PLANNING CONSULTATION RESPONSE

Application No	2025/0648
Proposal	Outline permission for the erection of 1 no detached dwelling considering access and layout (custom/self build).
Address	1A Sheffield Road, Birdwell, Barnsley, S70 5XB.
Date of Consultation Reply	15/12/2025
Consultee	Edward Jowett (Tree Officer)

Plan 1 Tree Constraints Plan showing the existing layout

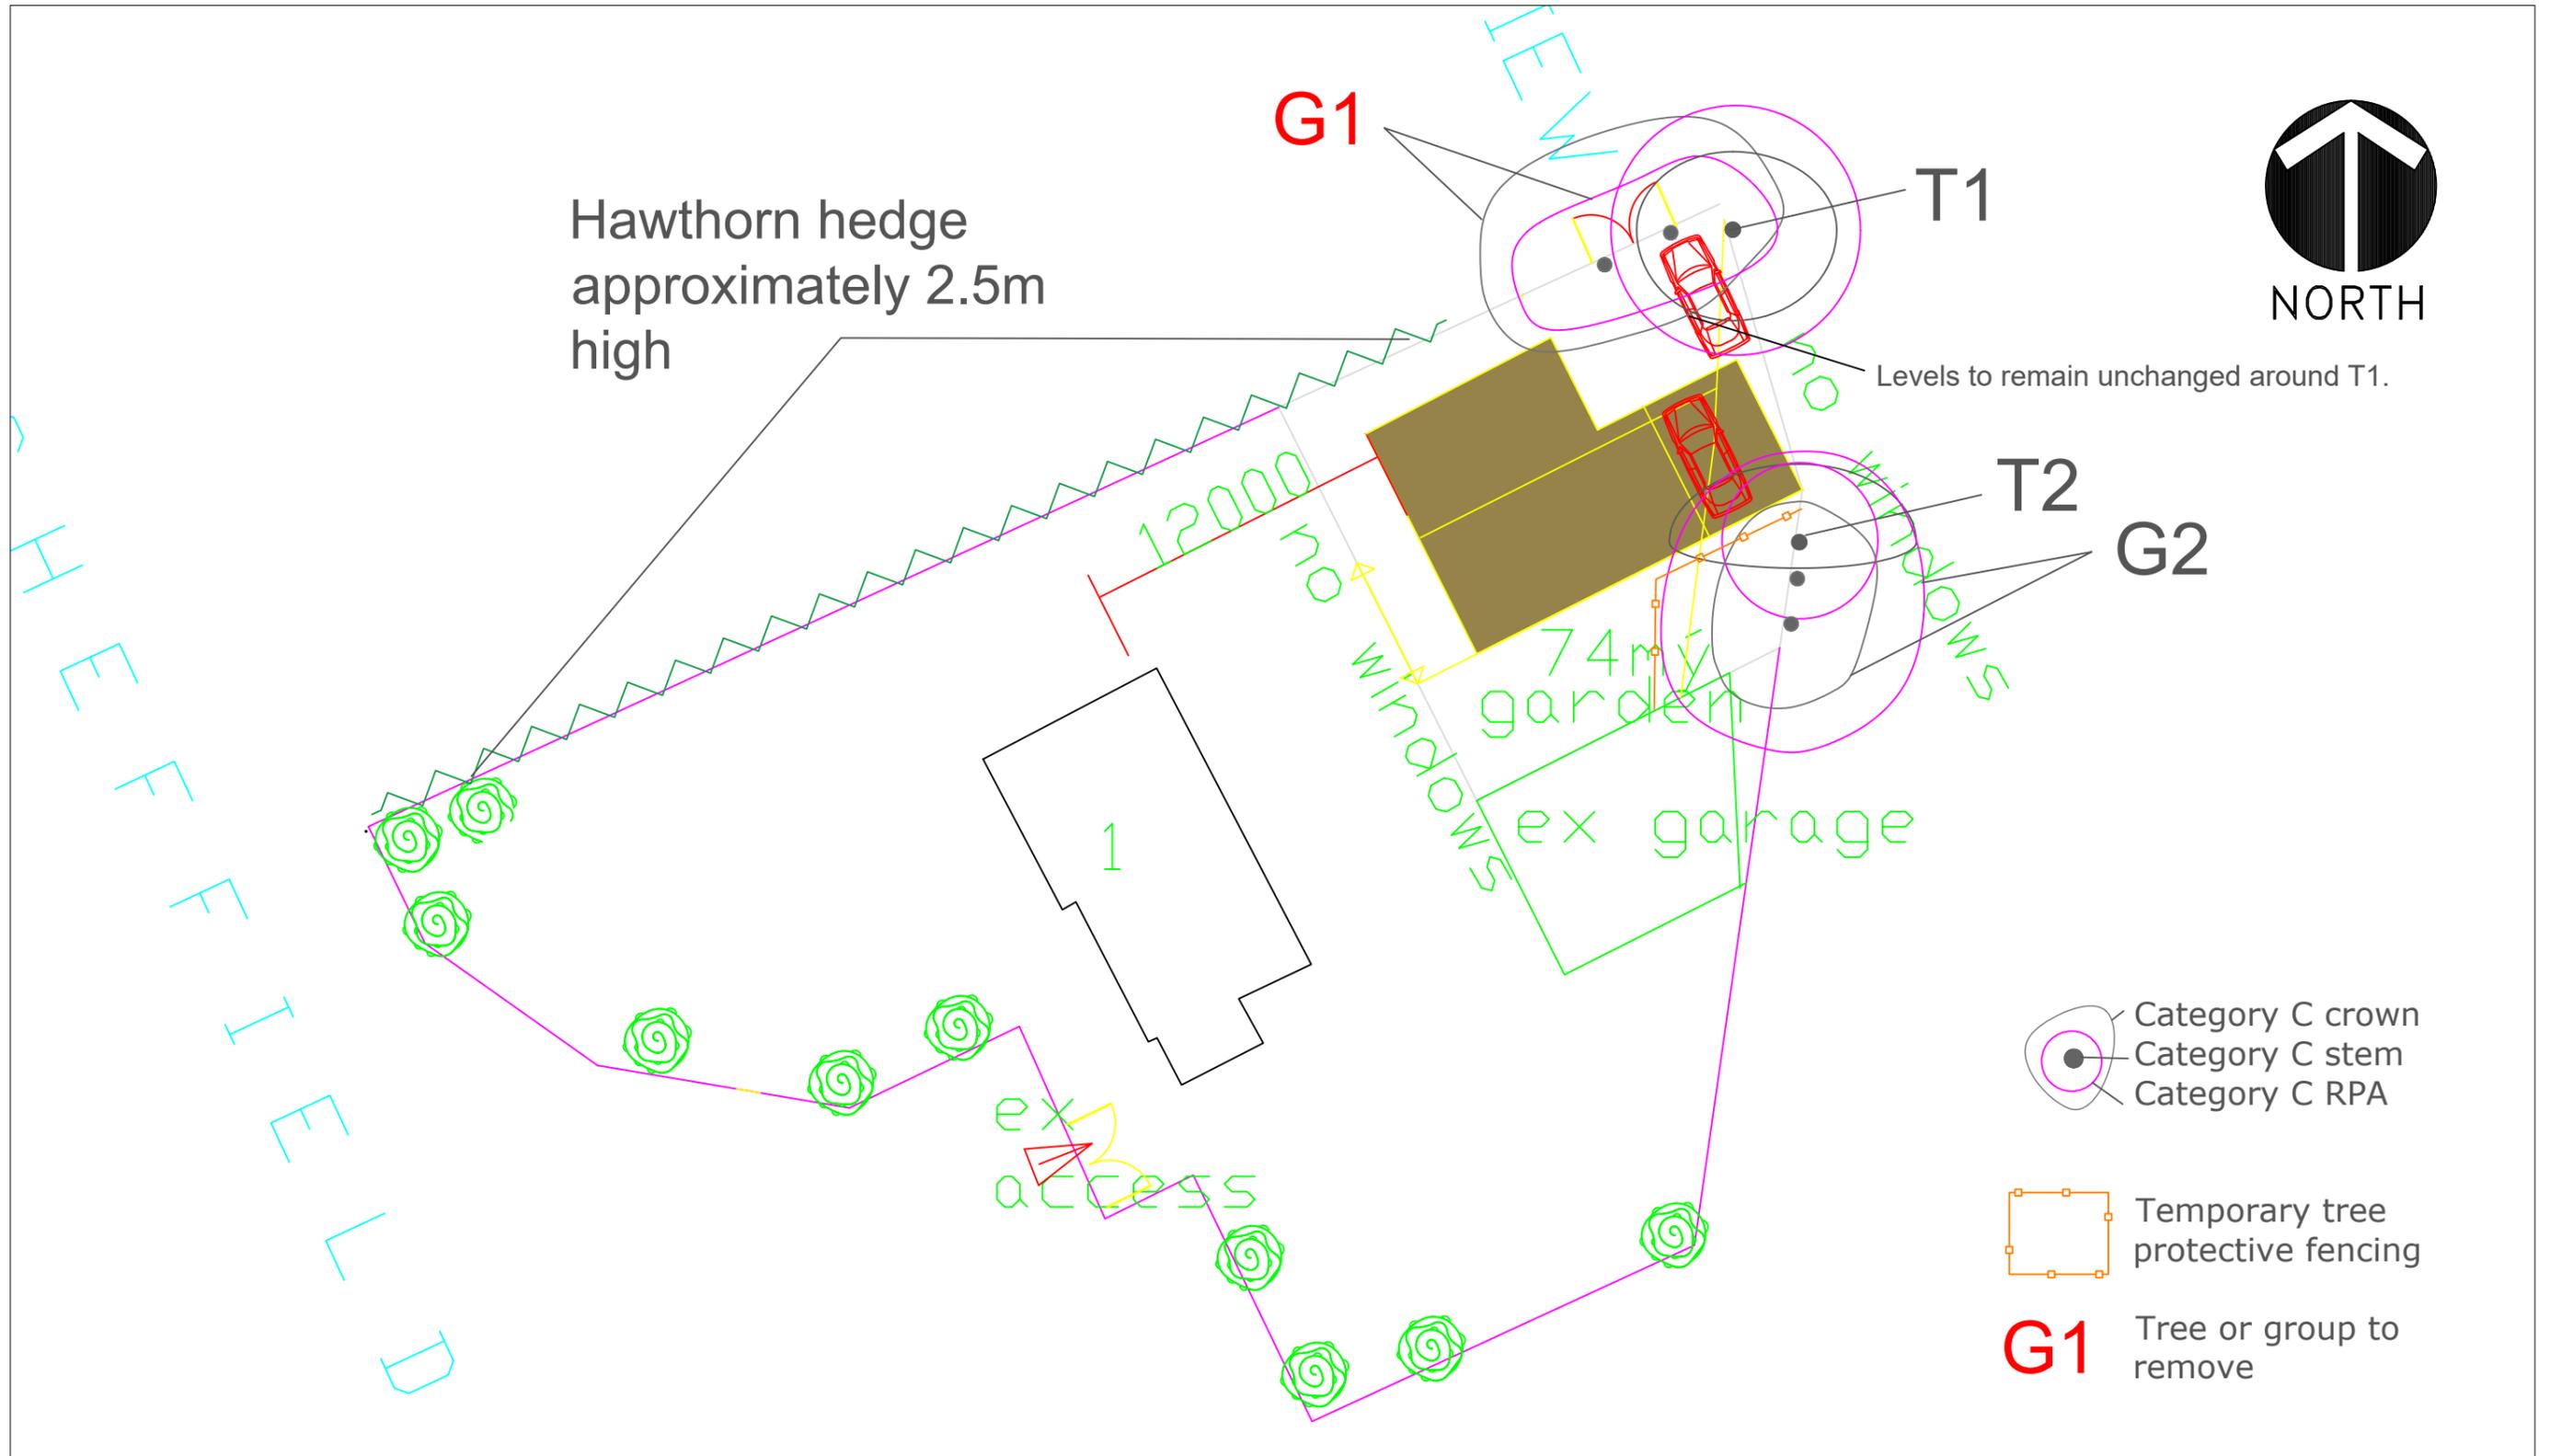
The application is to construct a new dwelling at the applicant property immediately adjacent to the boundary with the properties on Rockley Avenue. Unfortunately I have no option but to object to the proposal due in the main to the potential future impacts on trees belonging to these neighbours and in particular Beech tree T1 and Ash tree T2. These trees are outside the ownership of the site yet are both (still relatively small) large growing native trees with high potential future growth. The proposal as it stands shows these trees in close proximity to the proposed new dwelling with T2 likely to require pruning works to facilitate the development. As these trees grow they will undoubtedly cause proximity and shading issues with the dwelling all whilst being outside the control of the resident. The tree survey notes that the trees are not spectacular specimens and if they were on site there would not be any real objection to their removal and replacement as part of the scheme, however they aren't. Ultimately the retention of these trees is down to their owners and unless they were wanting to remove the trees the proposal must be assessed on the basis they will be retained and the constraint they pose now and the inevitable issues they will cause in the future must be taken into account. It would be remiss to not object to the scheme on this basis knowing that potential future conflicts with the trees and their owners would be almost inevitable with the trees in situ. With the owners of the trees being in full control over their retention we and not having heard otherwise we must assume they intent to retain them and that they will remain in situ.

If this application were approved as it is it is extremely likely there would be significant pressure on the trees and their owners due to proximity issues and shading from the owner of the proposed new dwelling. There would also potentially be ongoing significant works to prune back overhang to the boundary which would be far from ideal and would be detrimental to the aesthetics of the trees.
